December 7, 2023

RESPONSE TO REVIEWER COMMENTS

RE: HONG/KAO RESIDENCE REMODEL ADDITION AND NEW DADU
PERMIT 2306-124

Sheet No. **3.0**
 Project No. 2222
 Date: 6/7/23

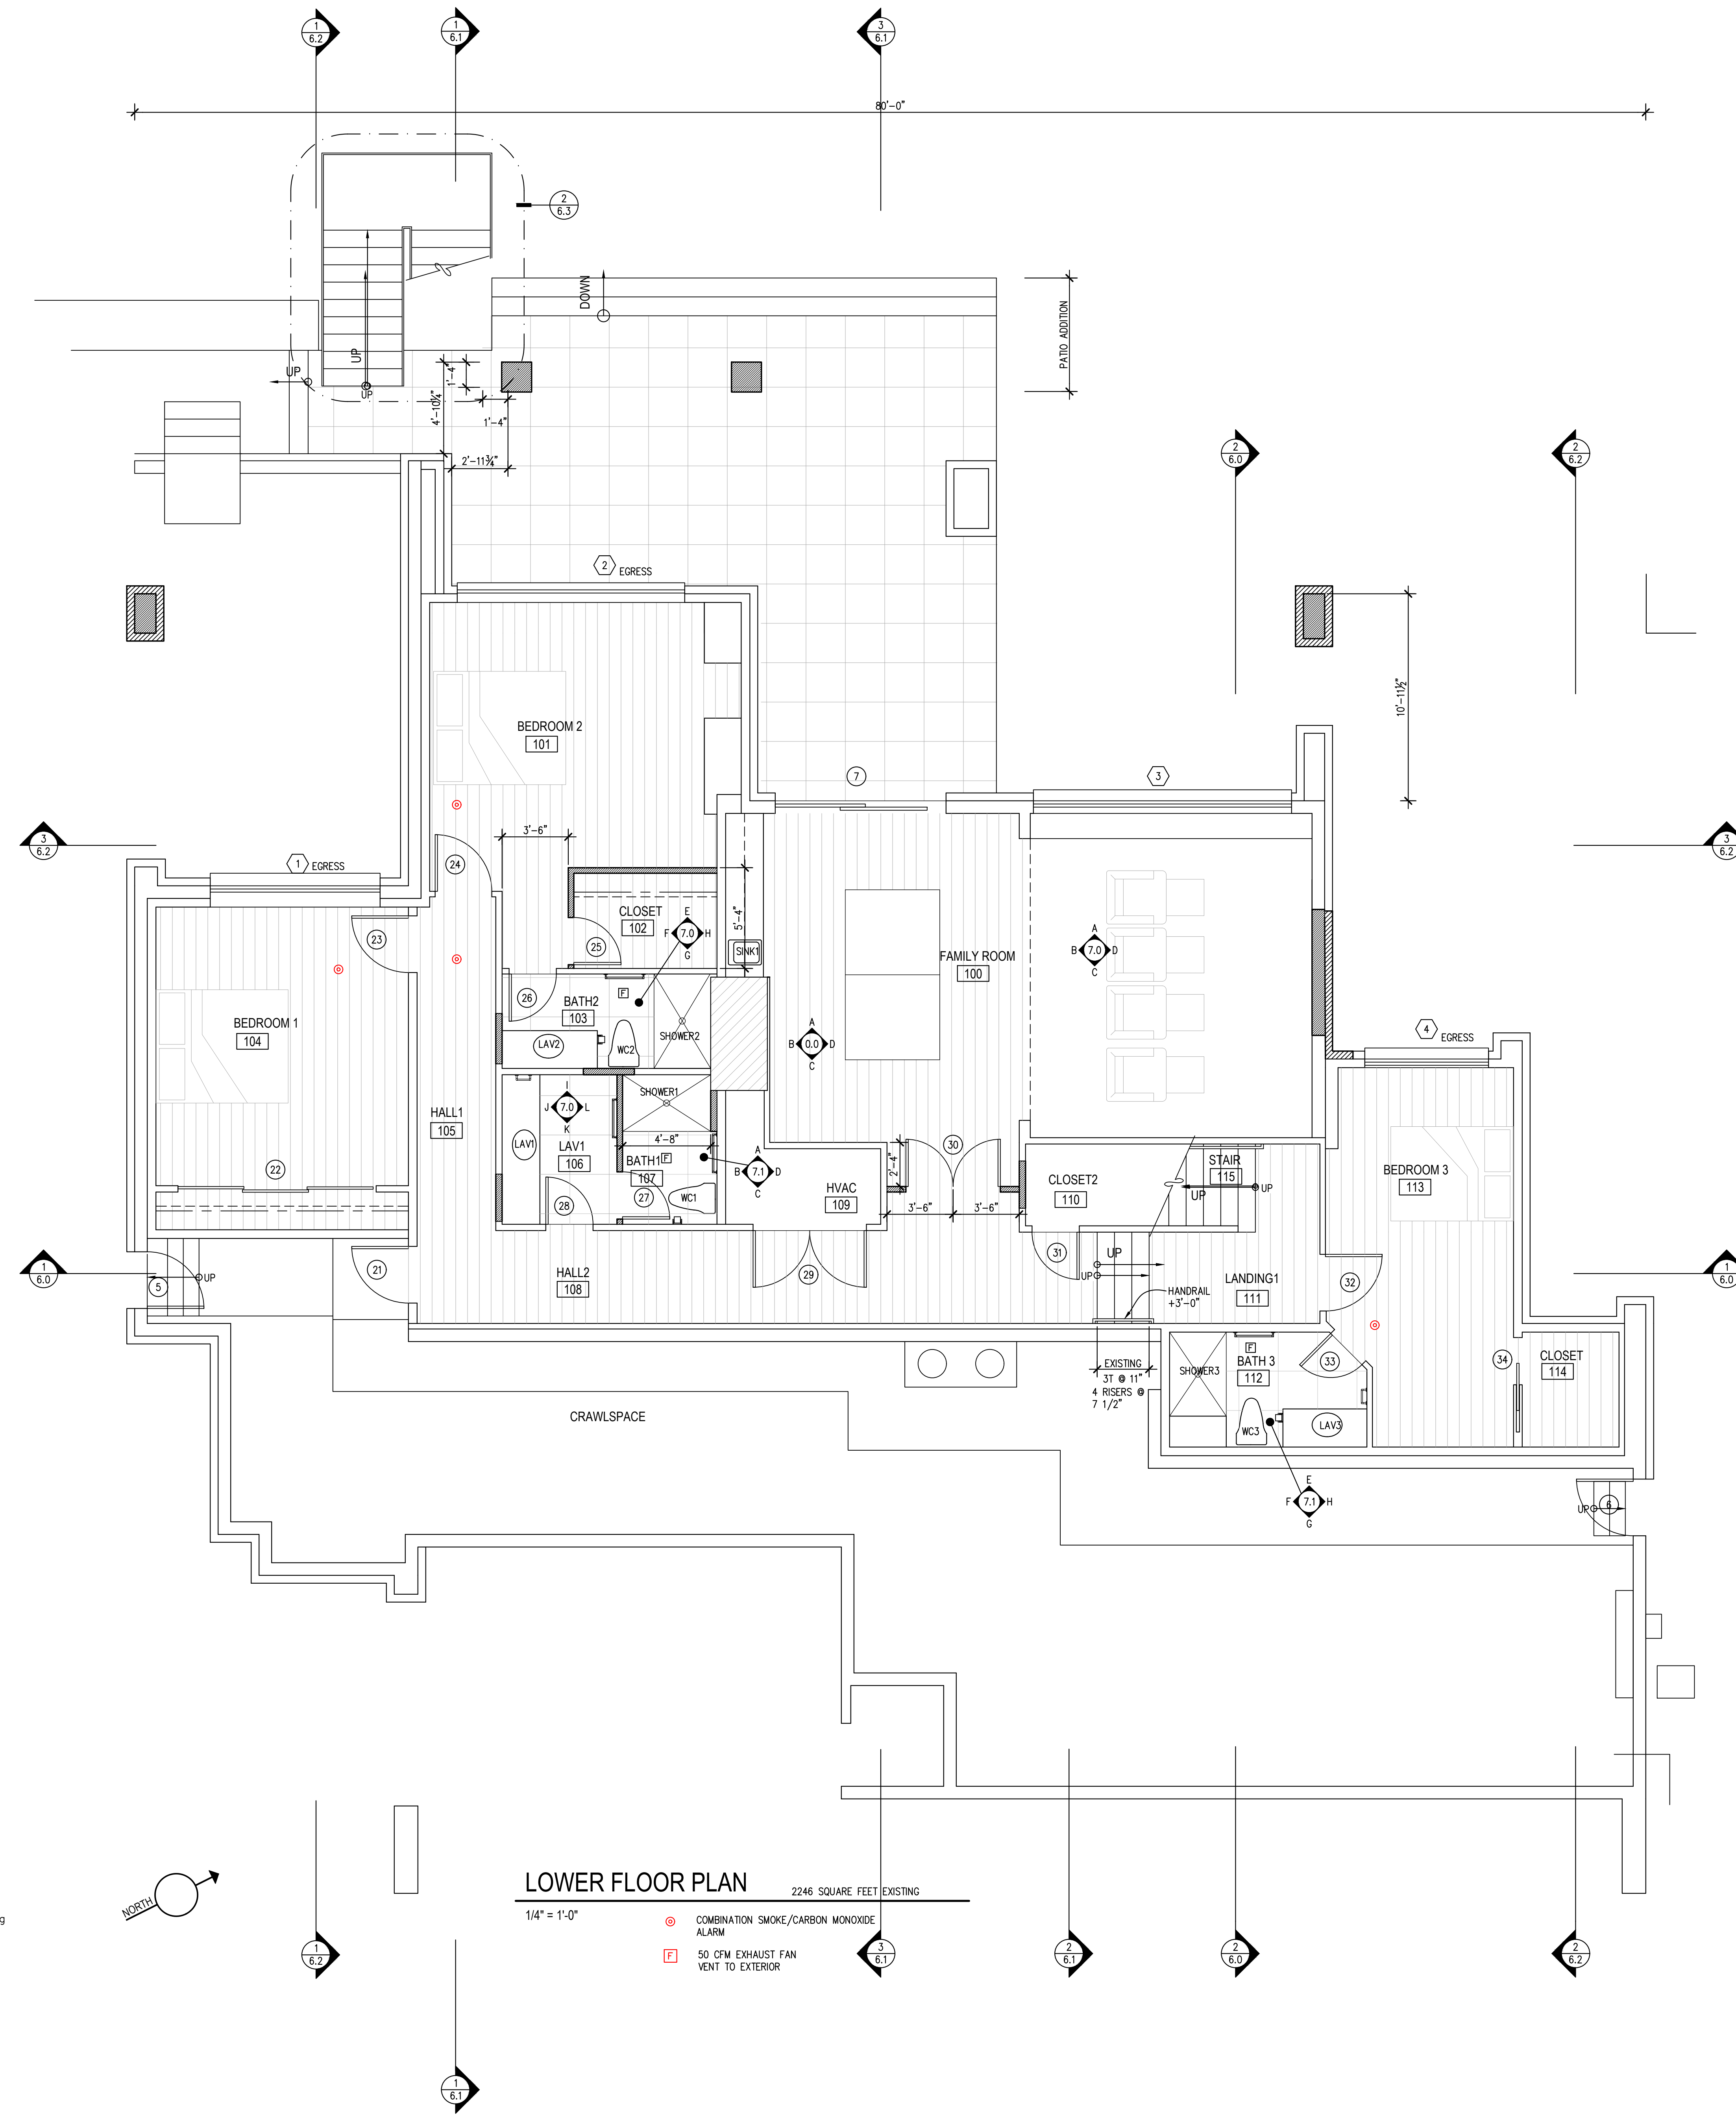
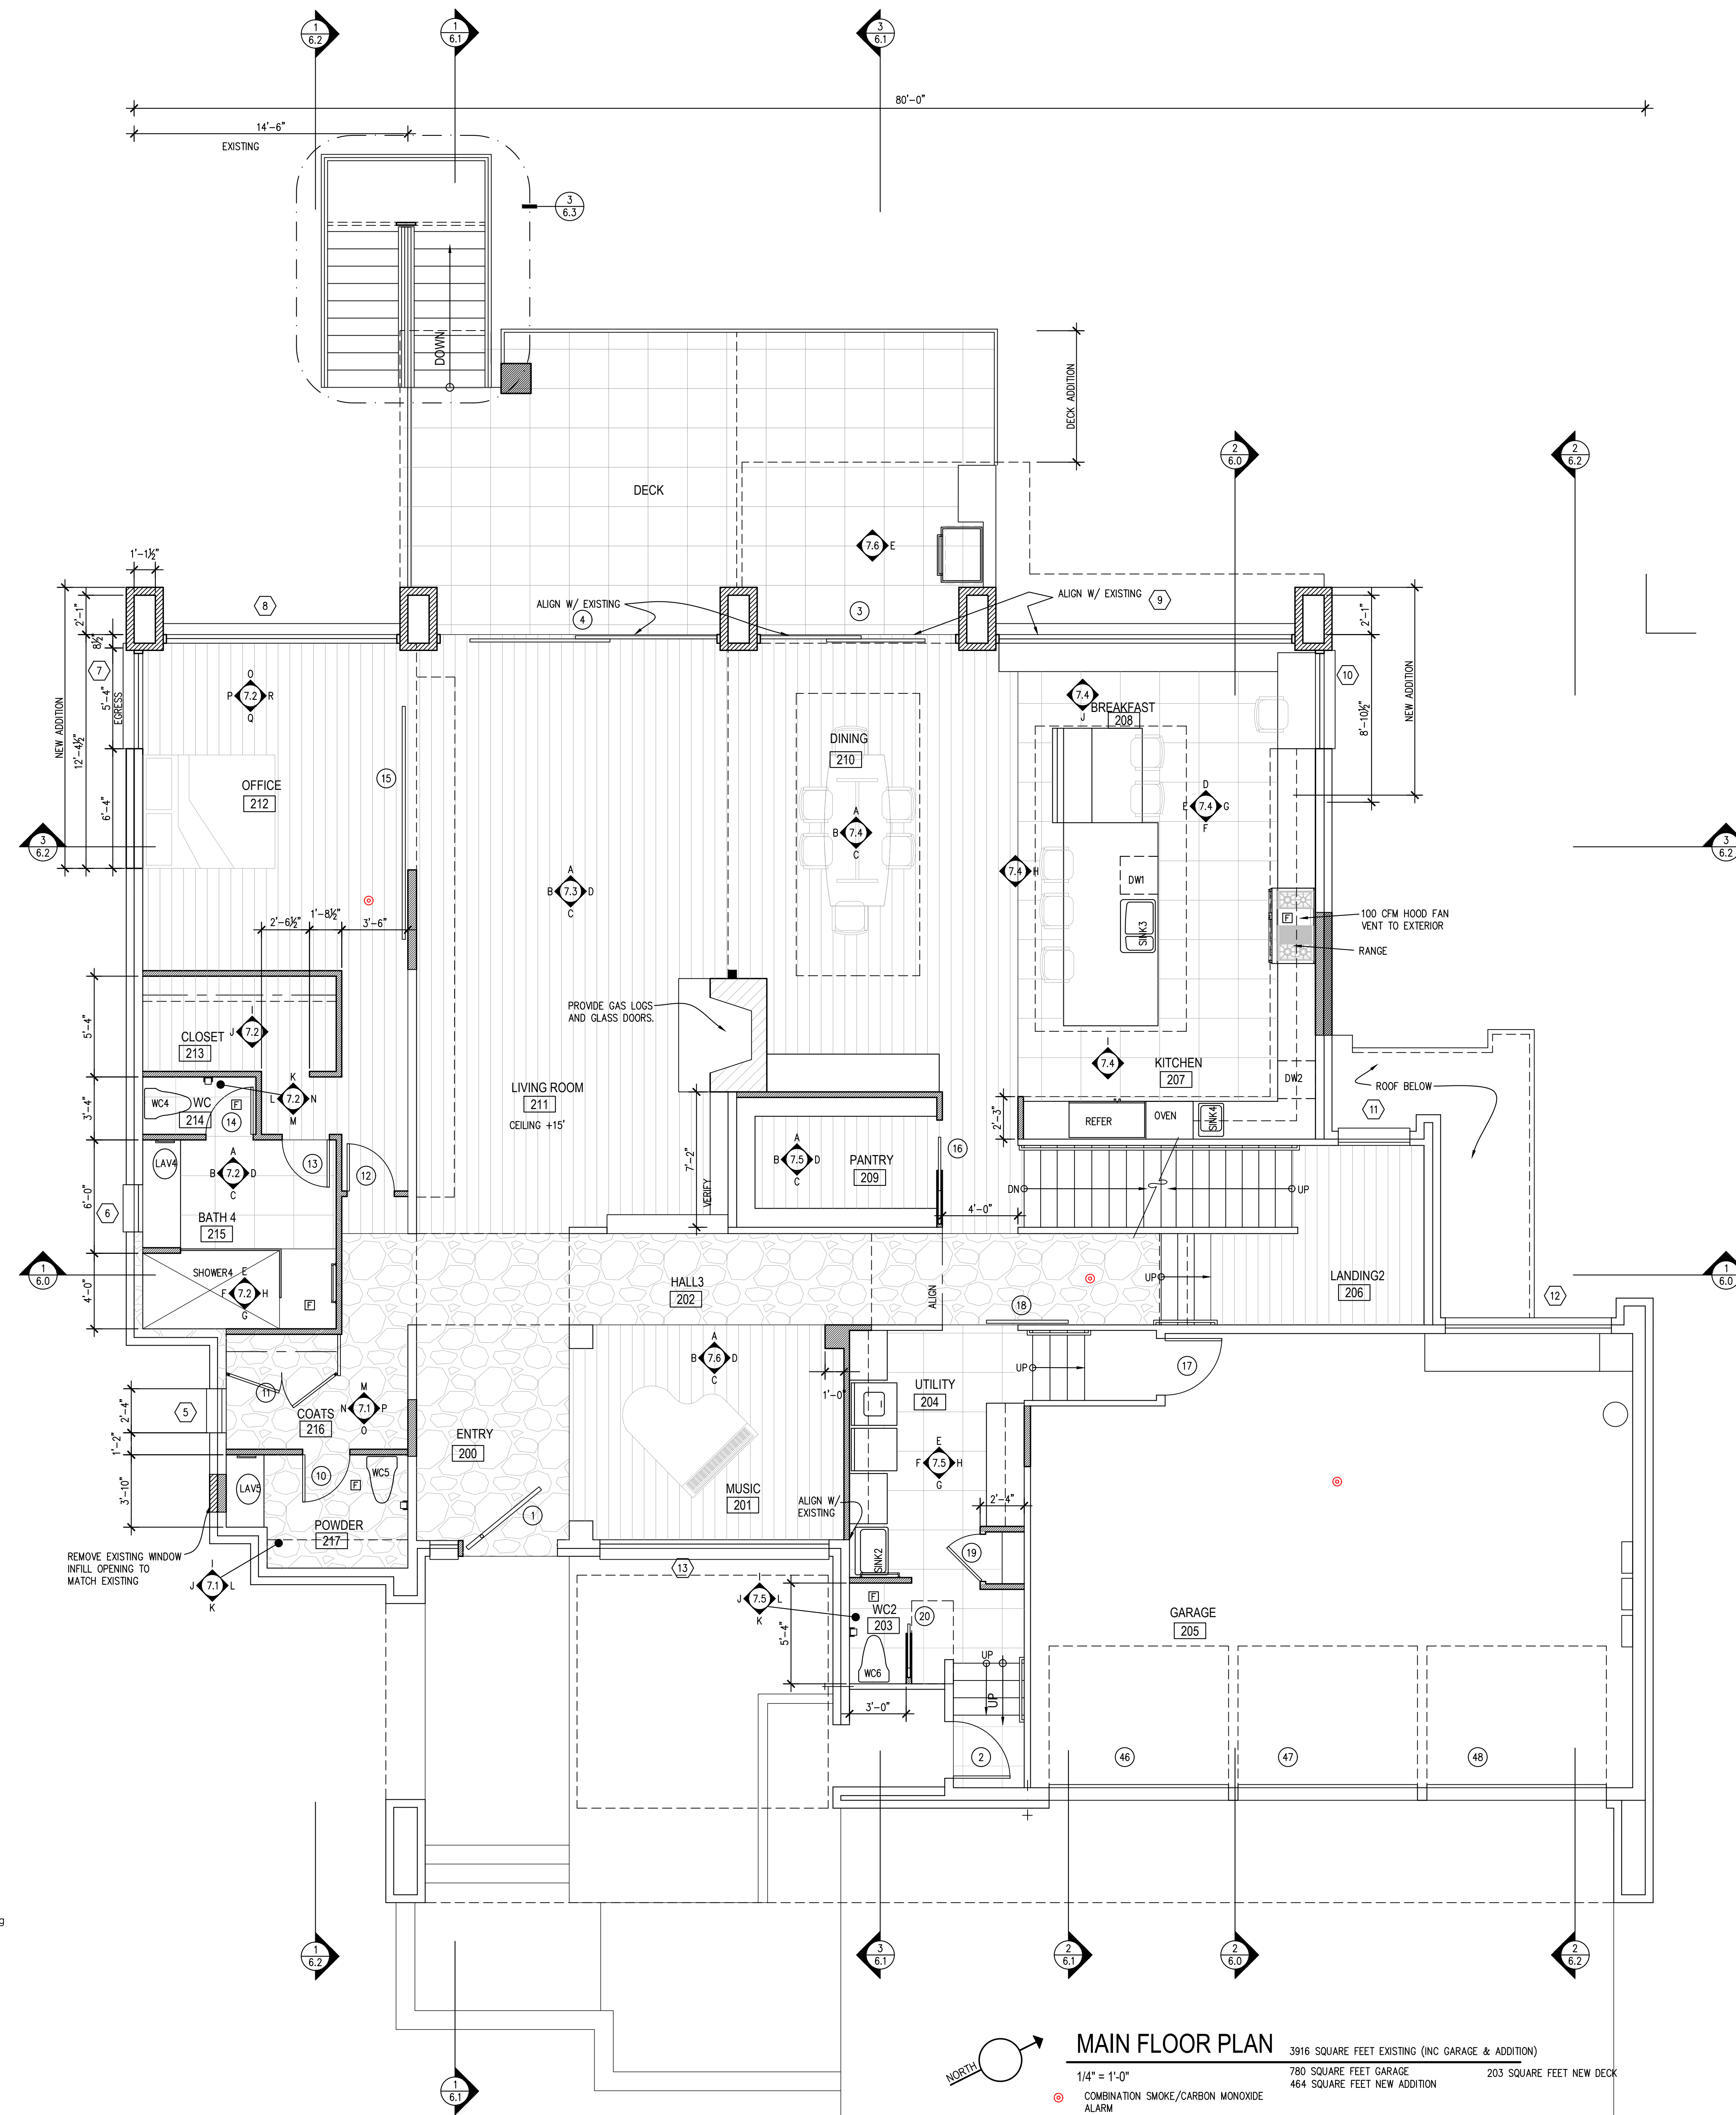
1. DADU condensing unit is shown on D1.0, the interior equipment is shown on 2.0 main floor utility room.
RESIDENCE condensing units are shown on 1.0, the interior equipment will go in room 109 labeled HVAC.
2. Table added to sheet 2.2
3. Ventilation rate note added to sheet 2.0 for residence. Note added to D2.1 of DADU plans.
4. Notes added to 2.0 and D2.1.

Sheet No. **3.2**
 Project No. 2222
 Date: 6/7/23

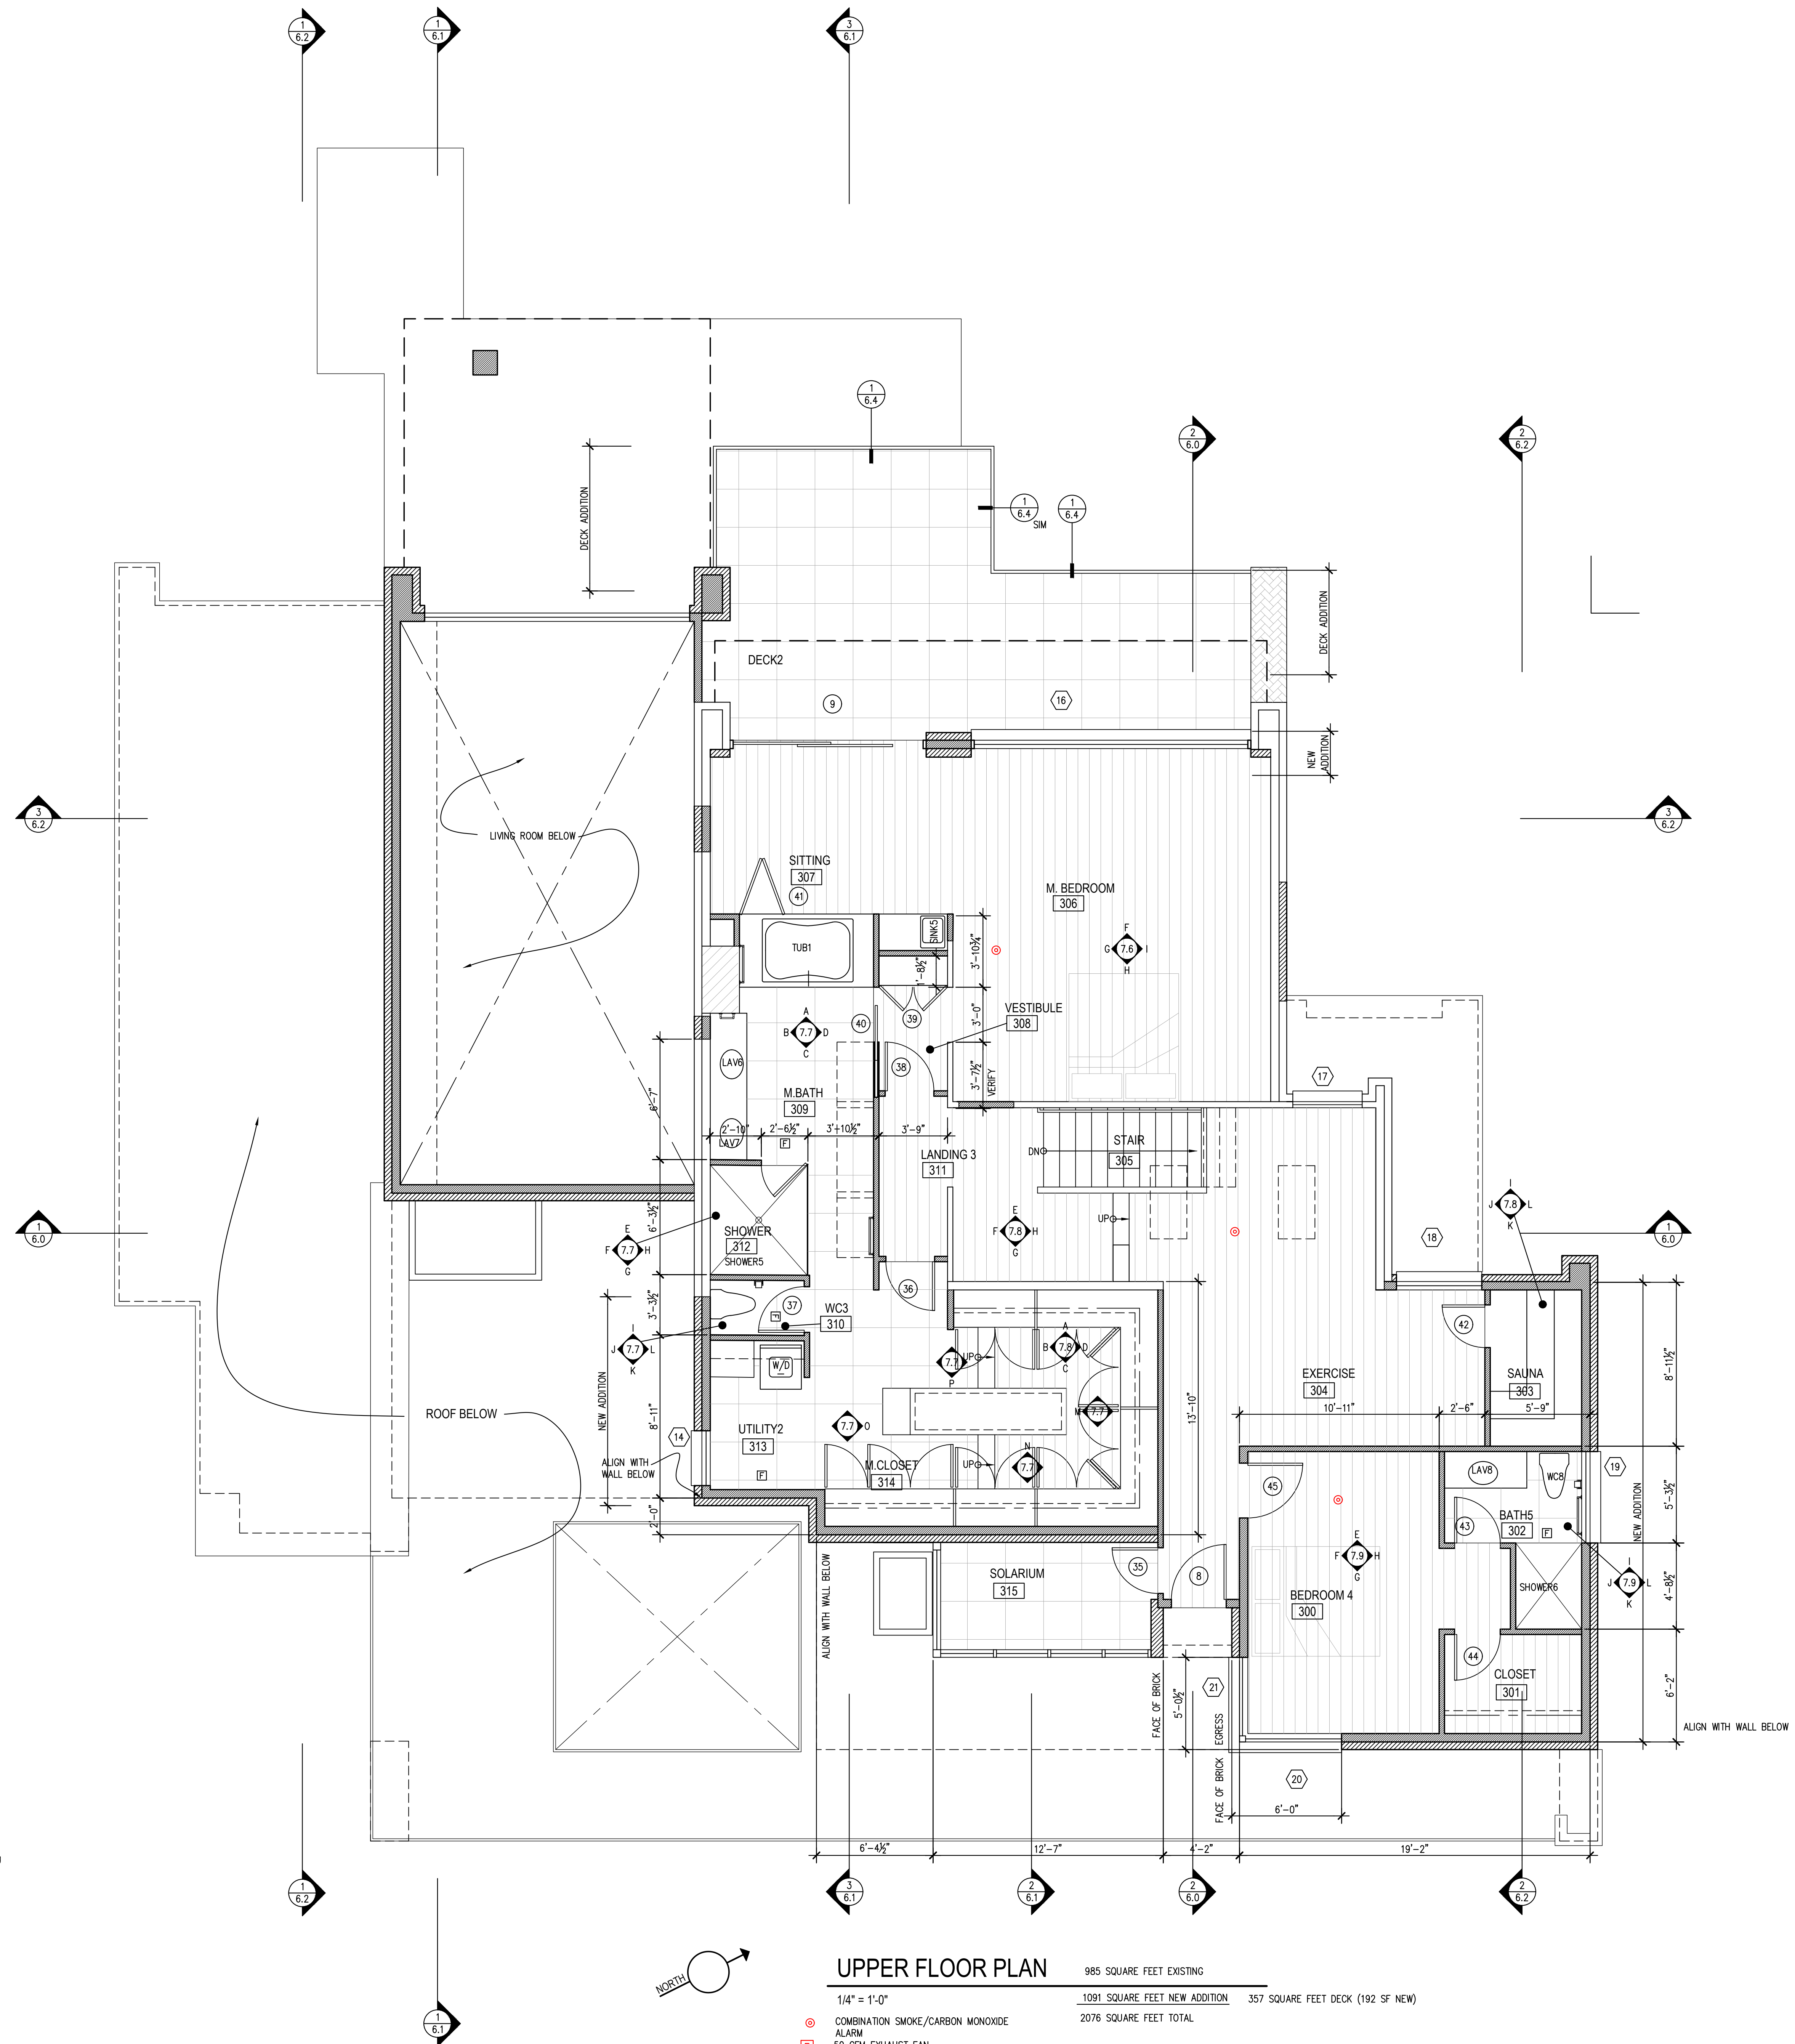
1. The heated area listed on 3.2 for the upper floor is correct. The area is calculated from the inside face of stud.
